11 September, 2012

**KOGARAH
CITY COUNCIL**

New Emergency Department at St George Hospital (SSD 5029)

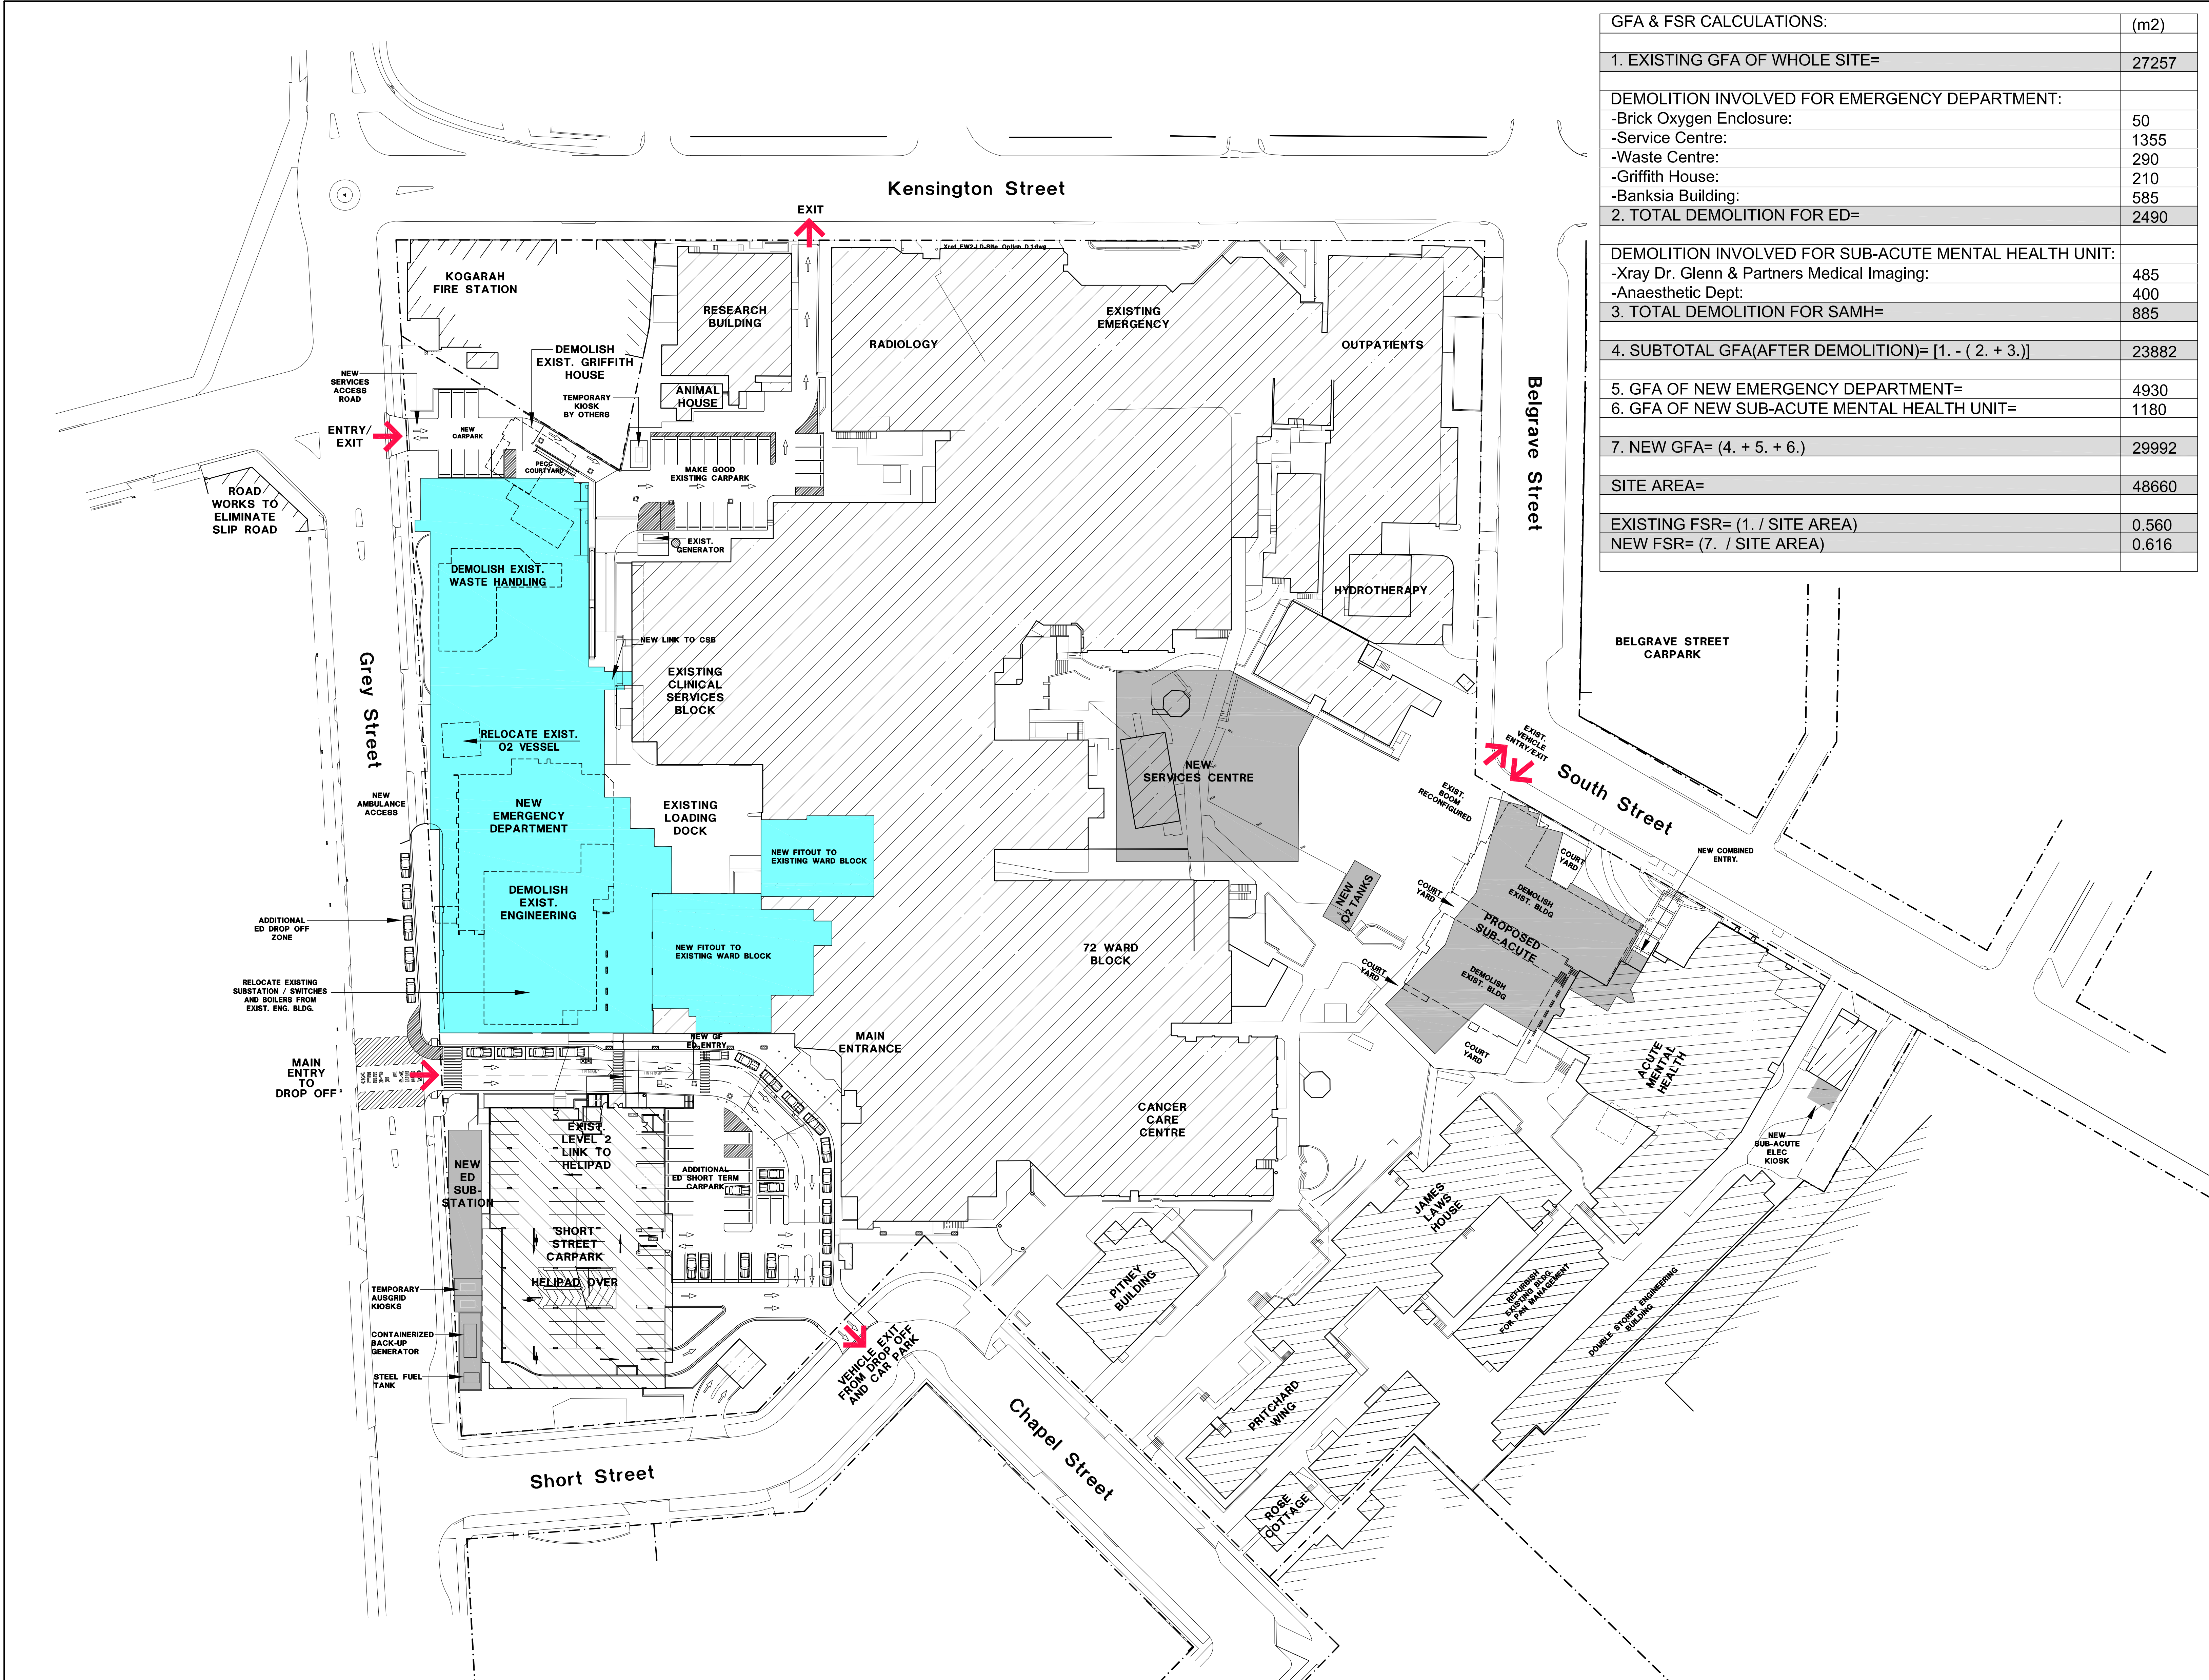
- It is proposed to remove one of the entrances to the multi level carpark off the main entry road from the Gray Street entrance to create a new at-grade carpark. This will result in all vehicles wanting to enter the multi level carpark having to drive past the Hospital entrance doors and also through the new marked pedestrian crossing. This results in a higher number of vehicles in this location and will increase the risk for pedestrians around this area. Council is seeking clarification that it is the intention of NSW Health to remove this entrance of the multi-level carpark.

- Proposed new carpark located near the multi level carpark (short term carpark) – the car park has been designed so that there is no turning area for vehicles (at the end of the blind aisle). Accordingly if all parking spaces are occupied, drivers will have to reverse out of the carpark. This is not considered to be an acceptable outcome.

- One of the submitted plans has an allocation for an additional drop off area for the new Emergency Department on Gray Street between the new driveway for the Ambulances and the existing main entry driveway. However another plan is proposing this area to be used for the relocated Bus Shelter and new Bus Zone. This discrepancy needs to be clarified.

- The access driveway from the Kensington Street entrance only has a width of 4 metres between kerbs and this is too narrow for two-way movement and does not comply with the requirements of AS2890.1 Section 2.5.2. It is requested that this be redesigned so as to comply. Alternatively, Council can recommend that this be conditioned to comply, however it may result in design changes.

- The access driveway linking the proposed carparks north of the new Emergency Department only has a width of 4 metres between kerbs and this is too narrow for two-way movement and does not comply with the requirements of AS2890.1 Section 2.5.2. If this is proposed to be one-way only, the AUSGRID service vehicle will have drive against the traffic flow to exit the site. Council does not consider this to be an appropriate outcome and as such should be redesigned to comply.

- The applicant has submitted turning templates for the AUSGRID service vehicle, however the vehicle can only exit the site if no vehicles are parked in the carpark as this area is used for the vehicle to turn around and the vehicle travels against the one-way flow mentioned above.

LANDSCAPE PLAN
SCALE 1:200

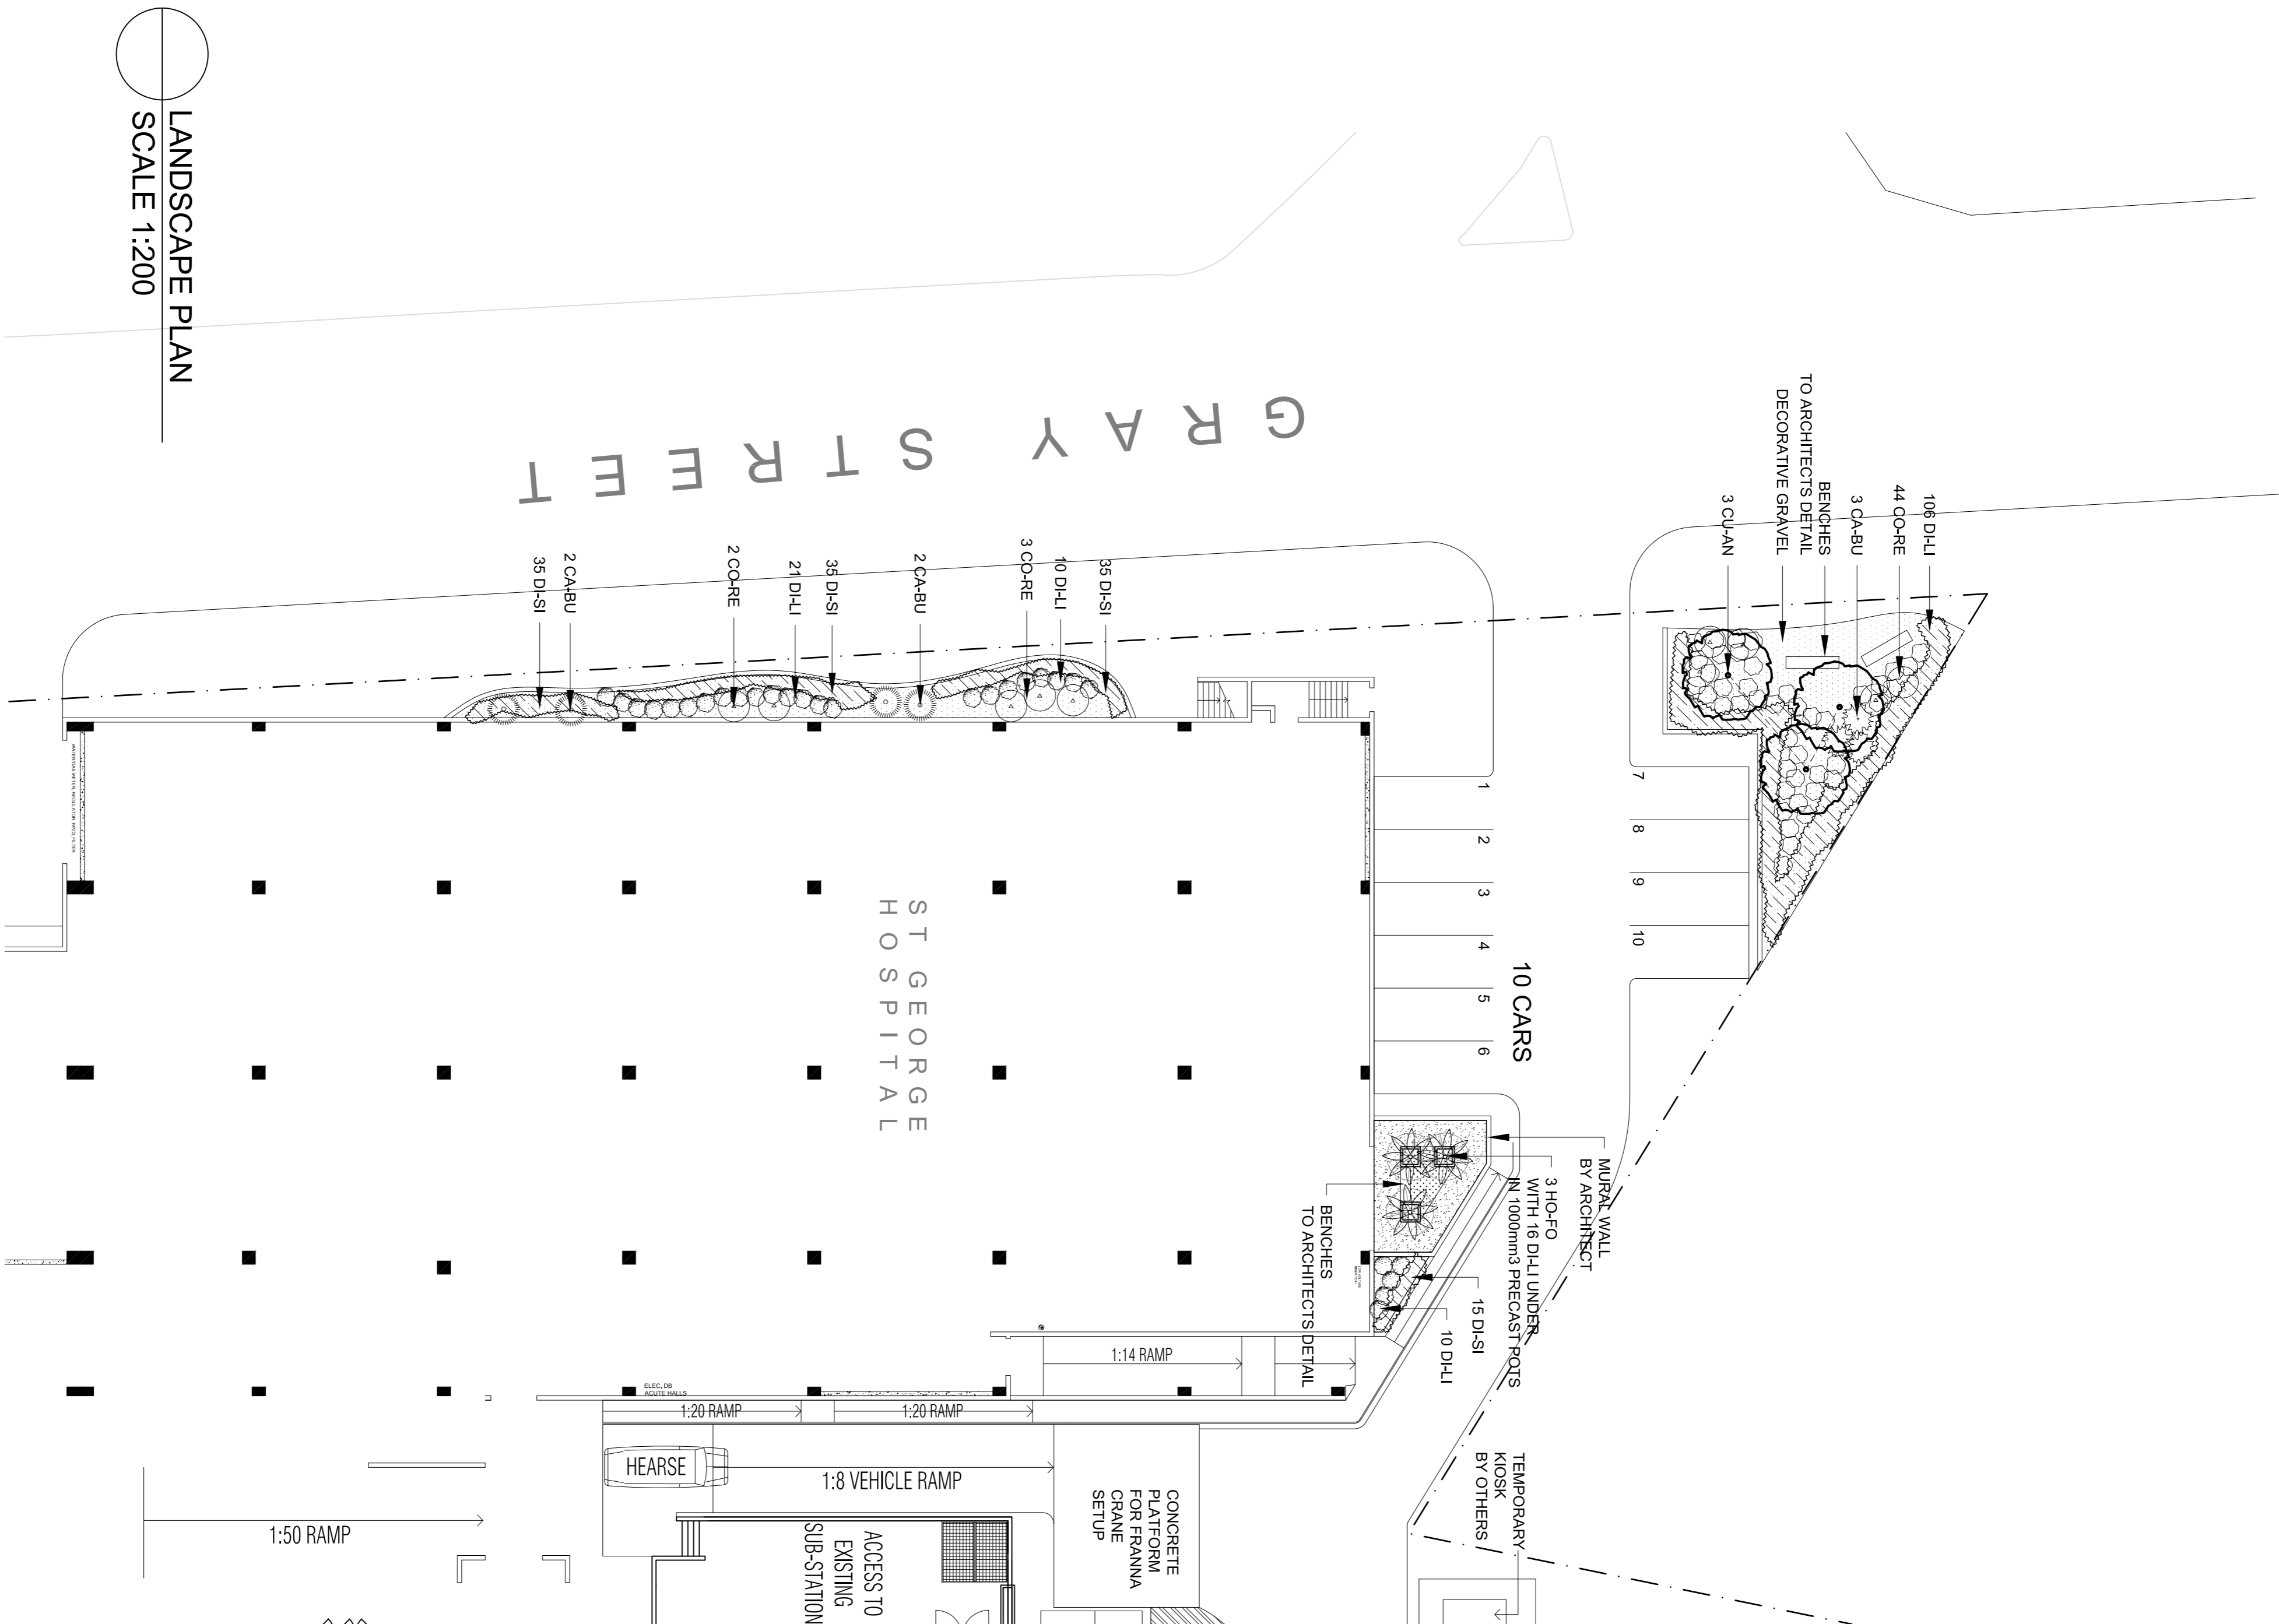
In point 1, a number of trees are proposed to be removed, including 1, 3 & 12, however further under the heading recommendation, it is recommended that trees 1, 3 & 12 be retained if the development is approved as these are considered to be of high significance – this needs to be clarified as Council's Landscape Officer has also requested that these 3 trees be retained, and as such a redesign may be required.
